December 23rd, 2013

Project Name: Munjoy Heights
Six new buildings comprising 29 residential townhouses; one existing house on reconfigured lot

Project ID: 2013-228

Project Address: 79 Walnut Street

SR-2

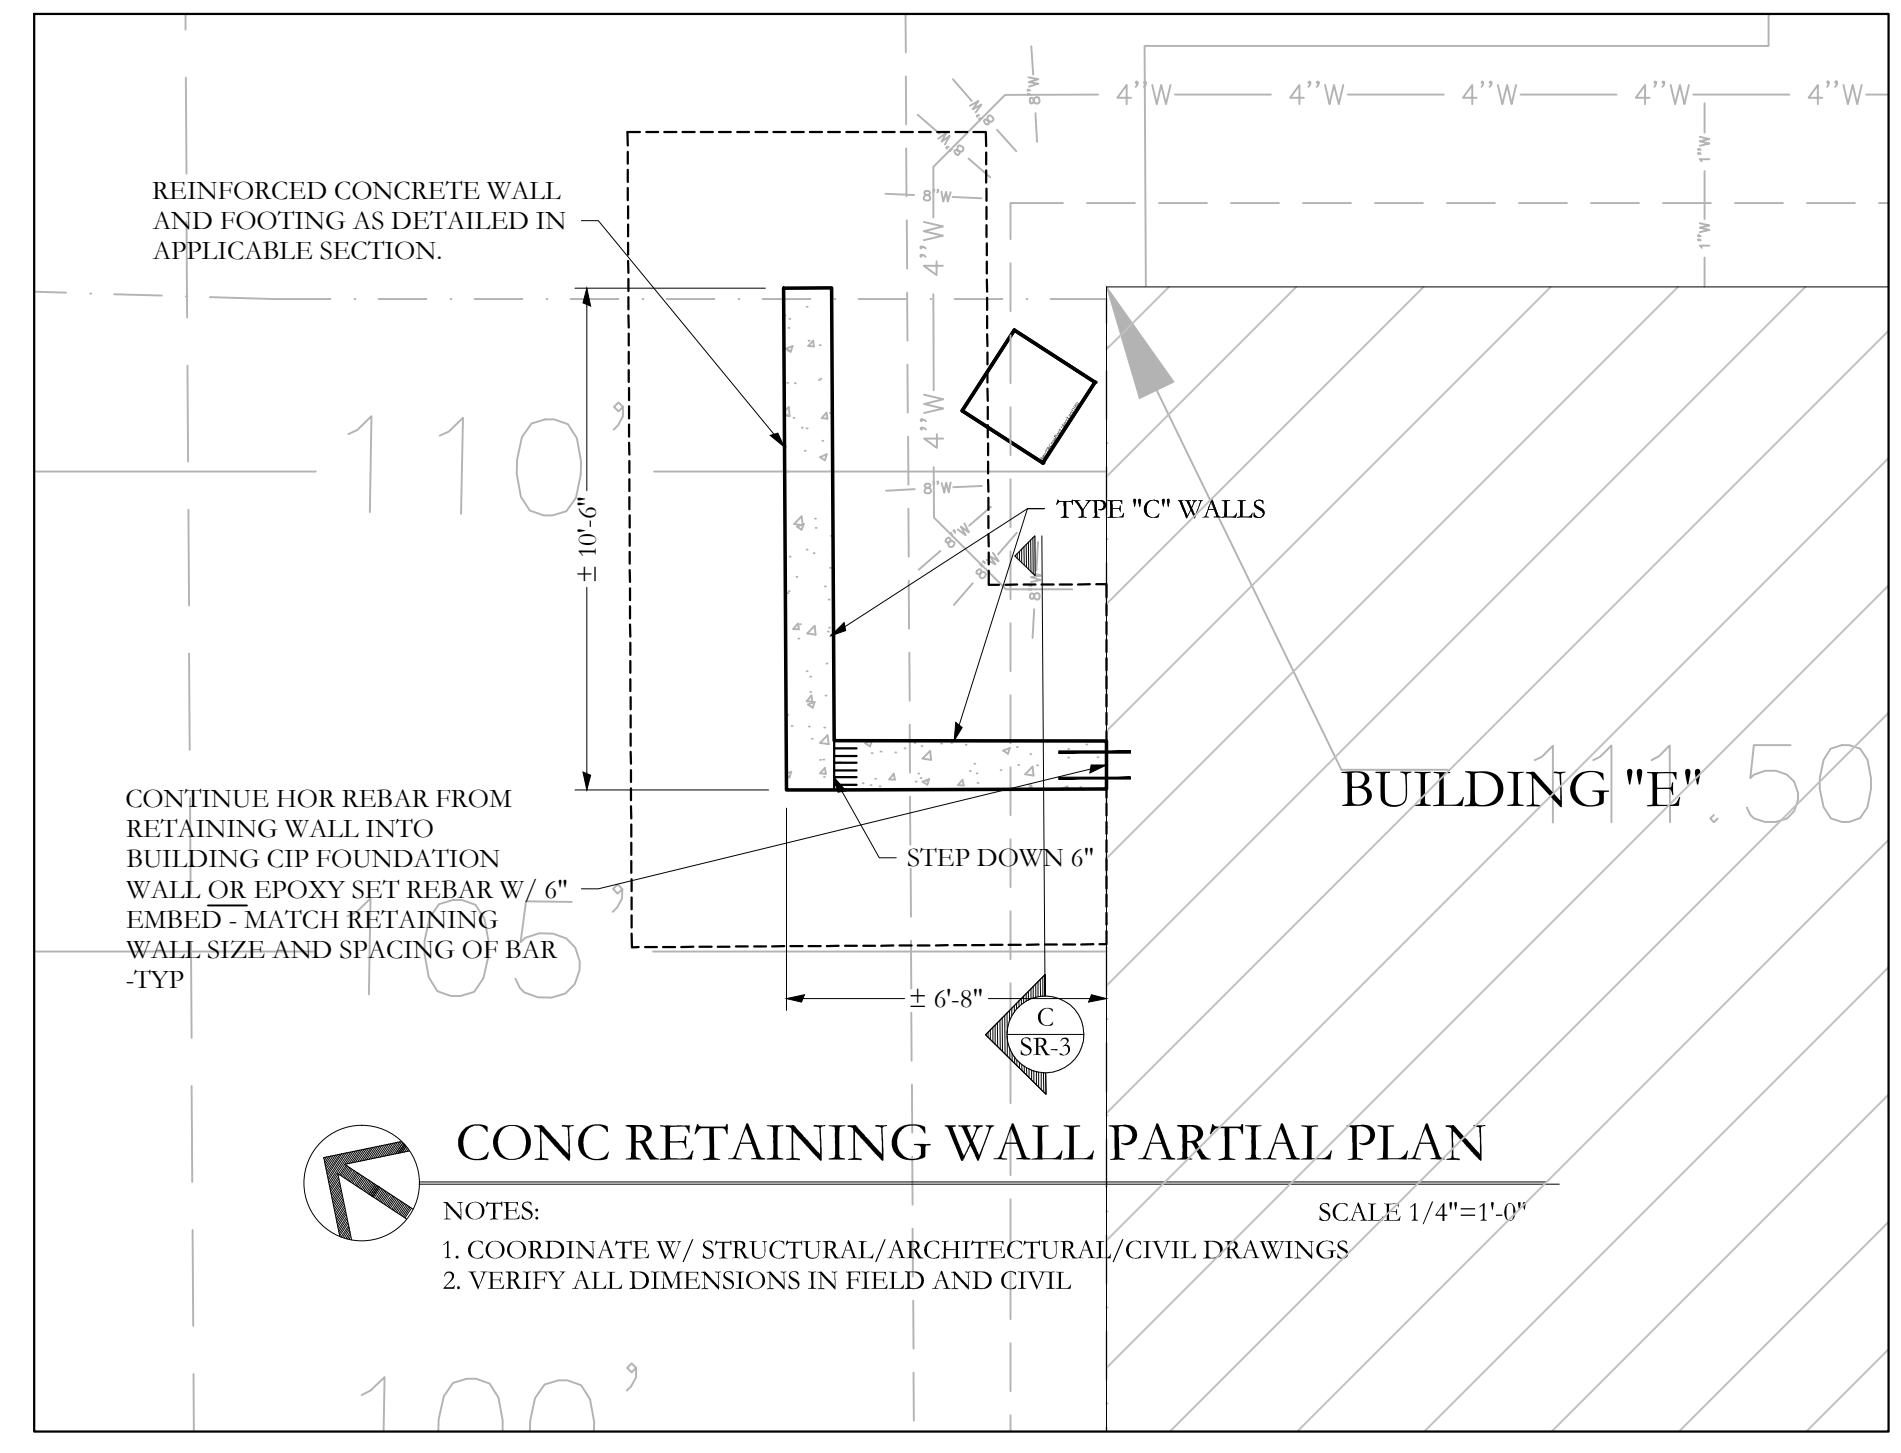
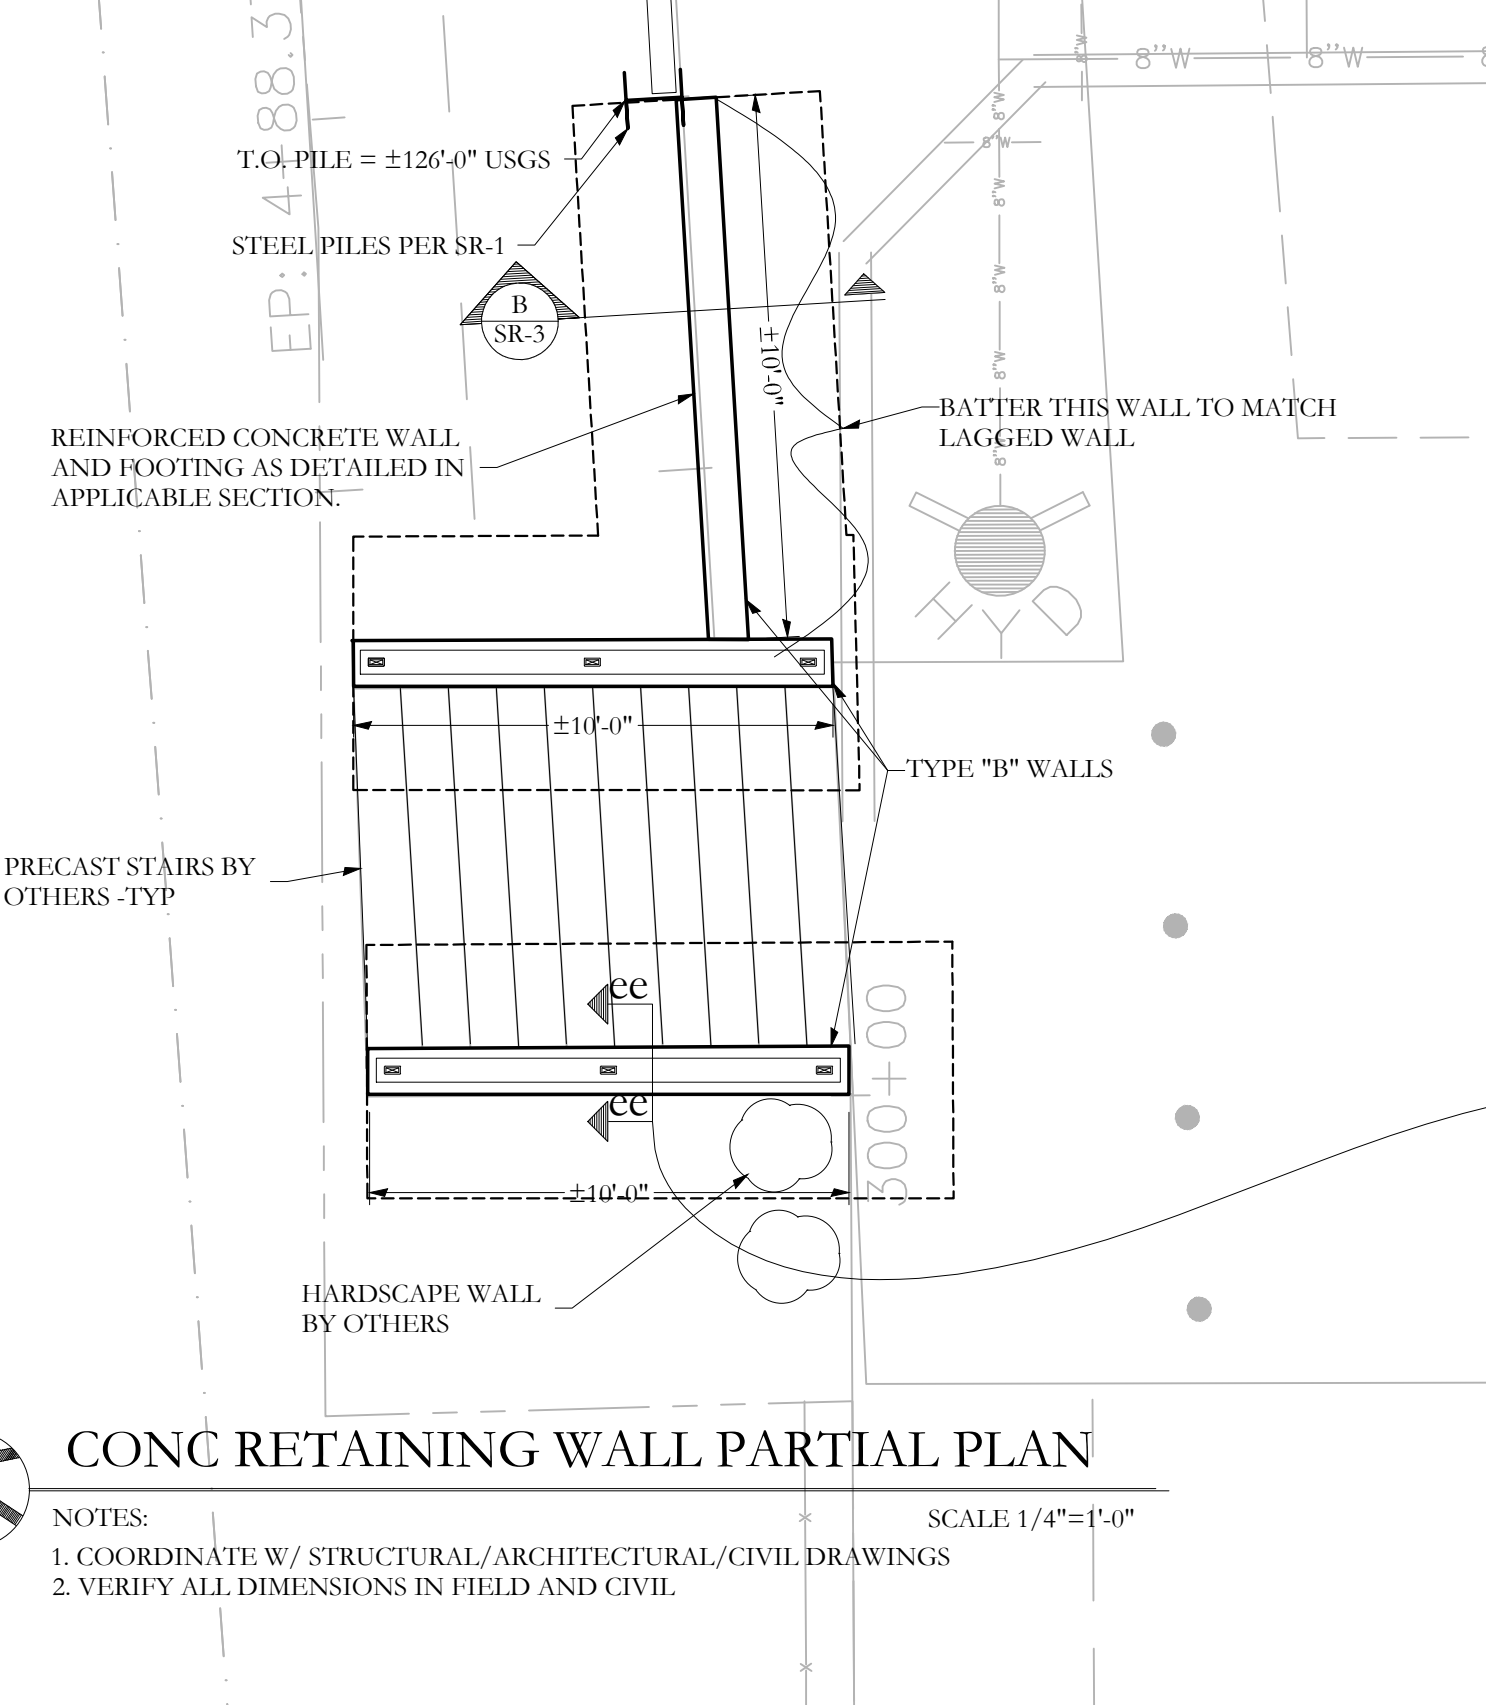
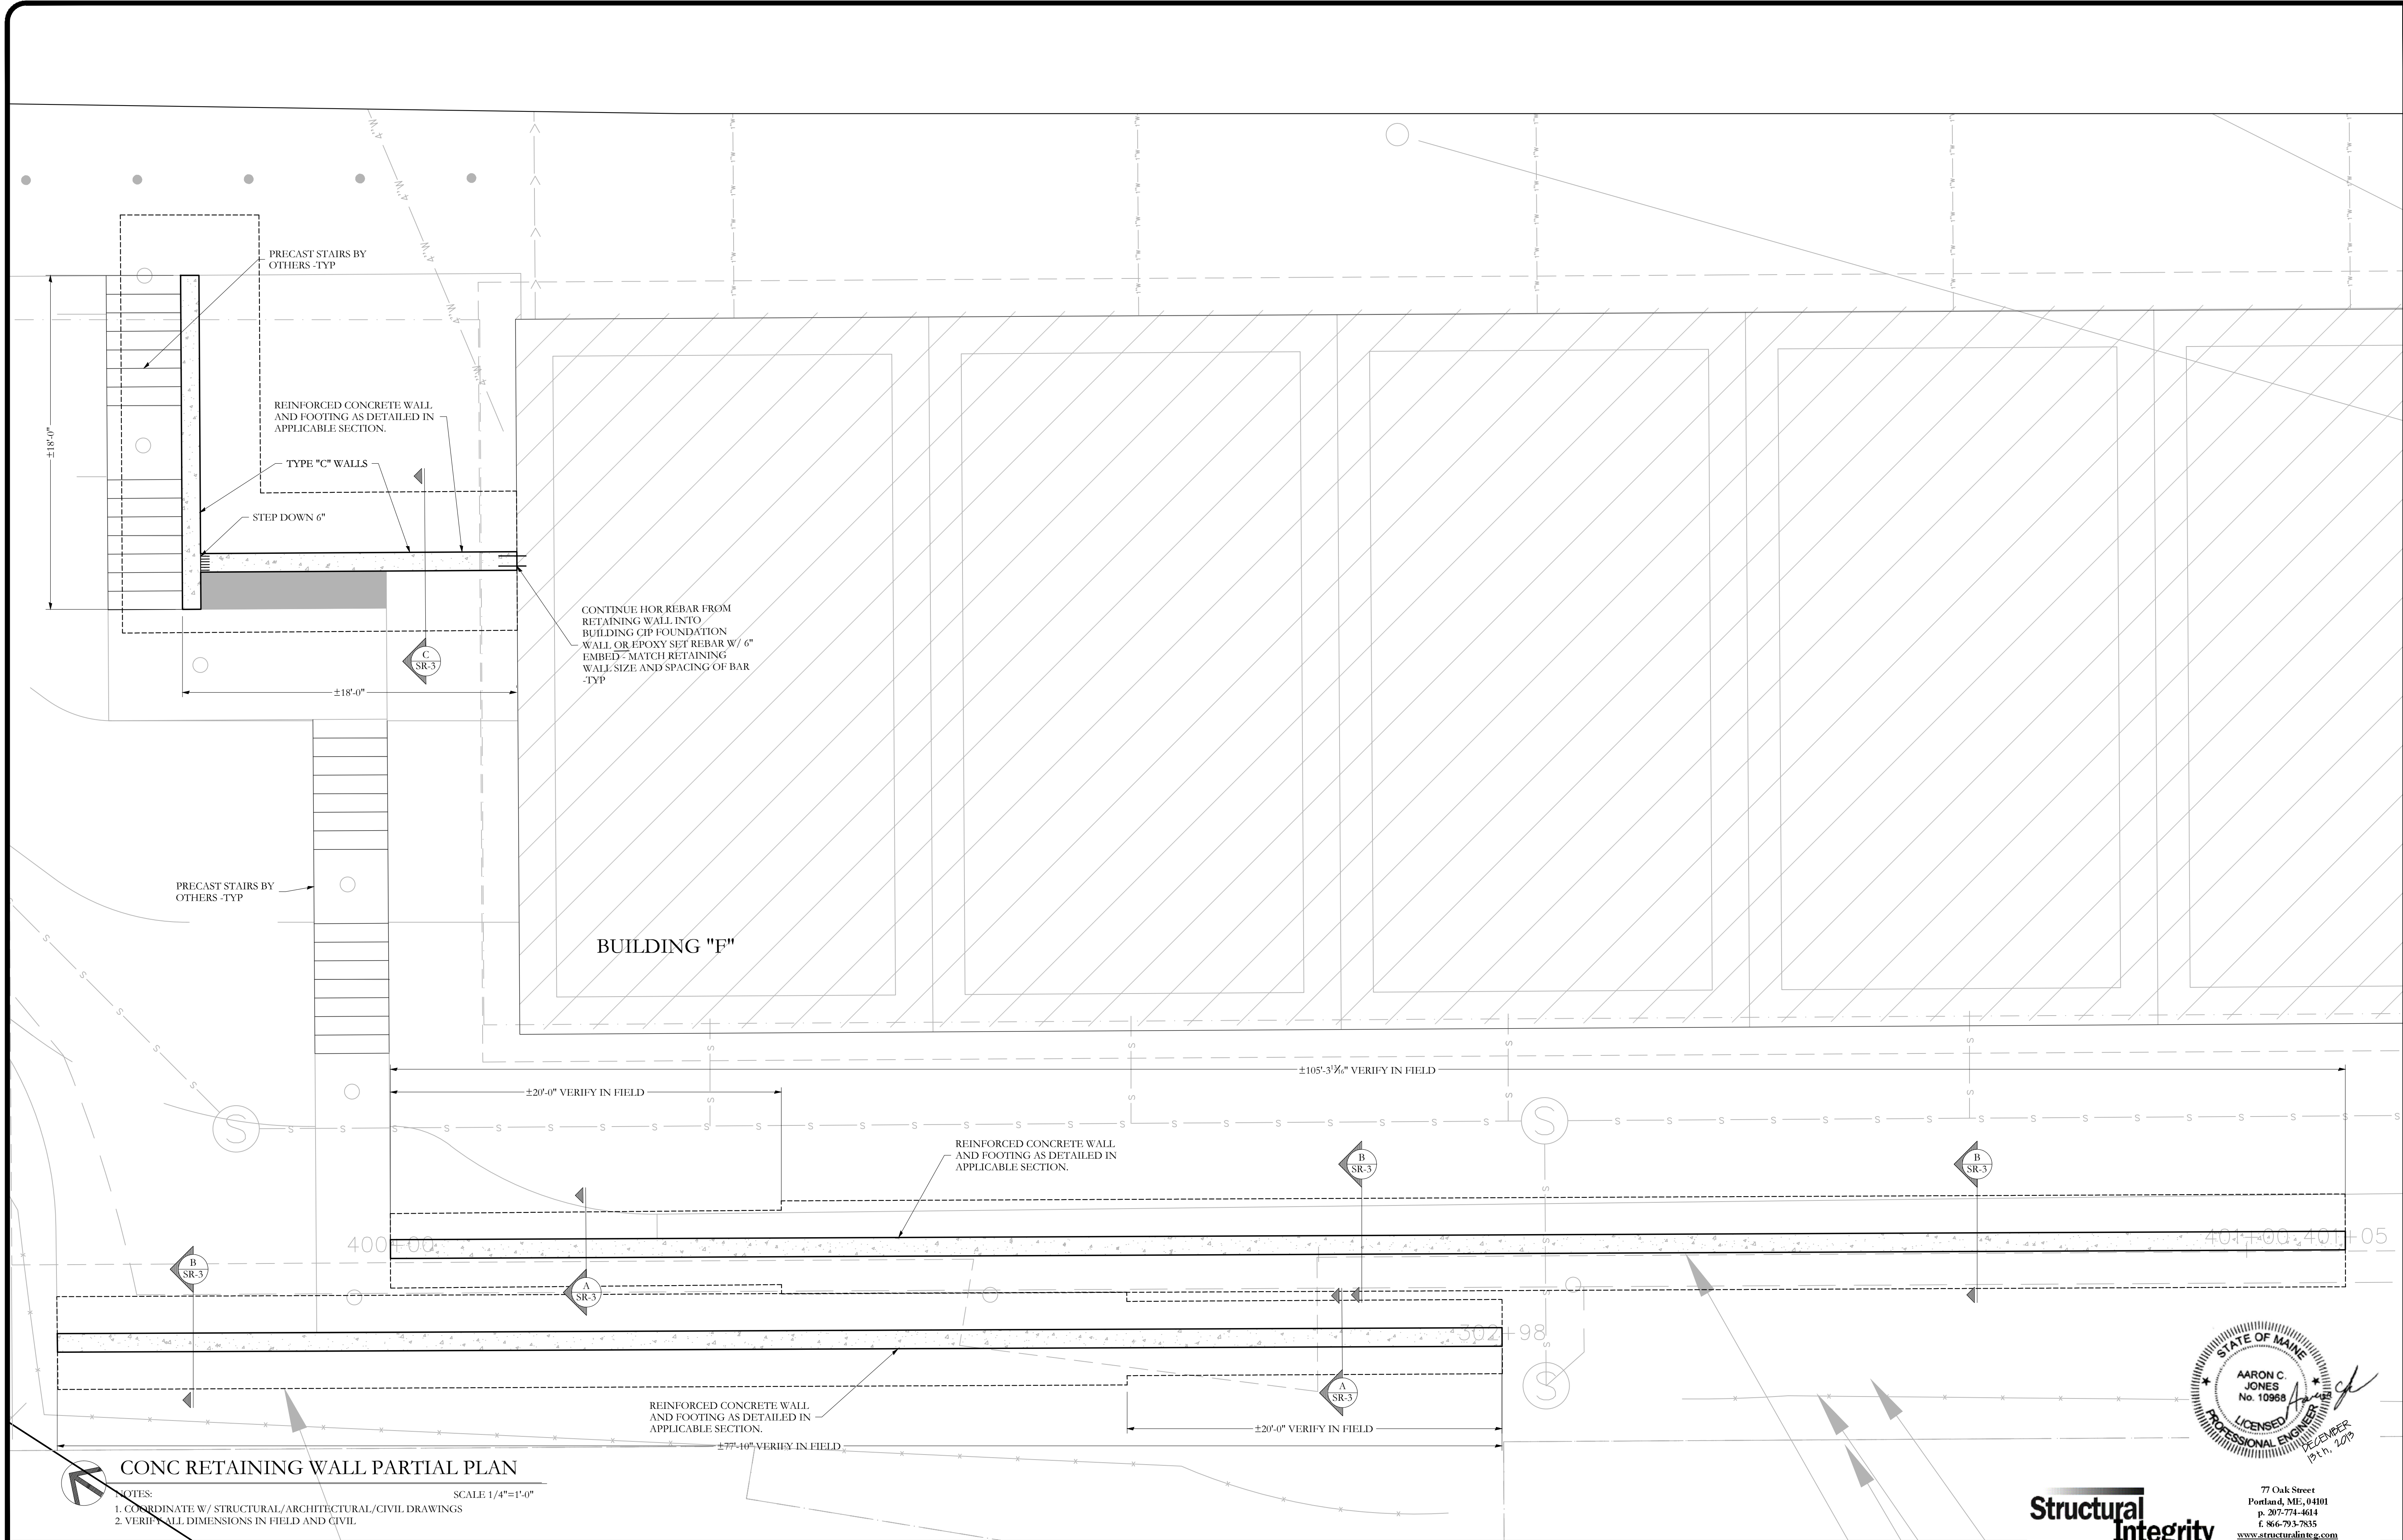
- vi. The applicant has noted on Plans Sheet C-32 & C-33 that Summit Engineering Services in coordination with Structural Integrity Consulting Engineers, Inc shall provide the retaining wall design, global stability analysis, and the design of the temporary soil restraint measures, as required. The referenced retaining wall designs shall be completed, stamped by a professional engineer, and submitted to the City of Portland Inspections Department and Planning Authority as part of the Building Permit process prior to construction of any retaining walls; and
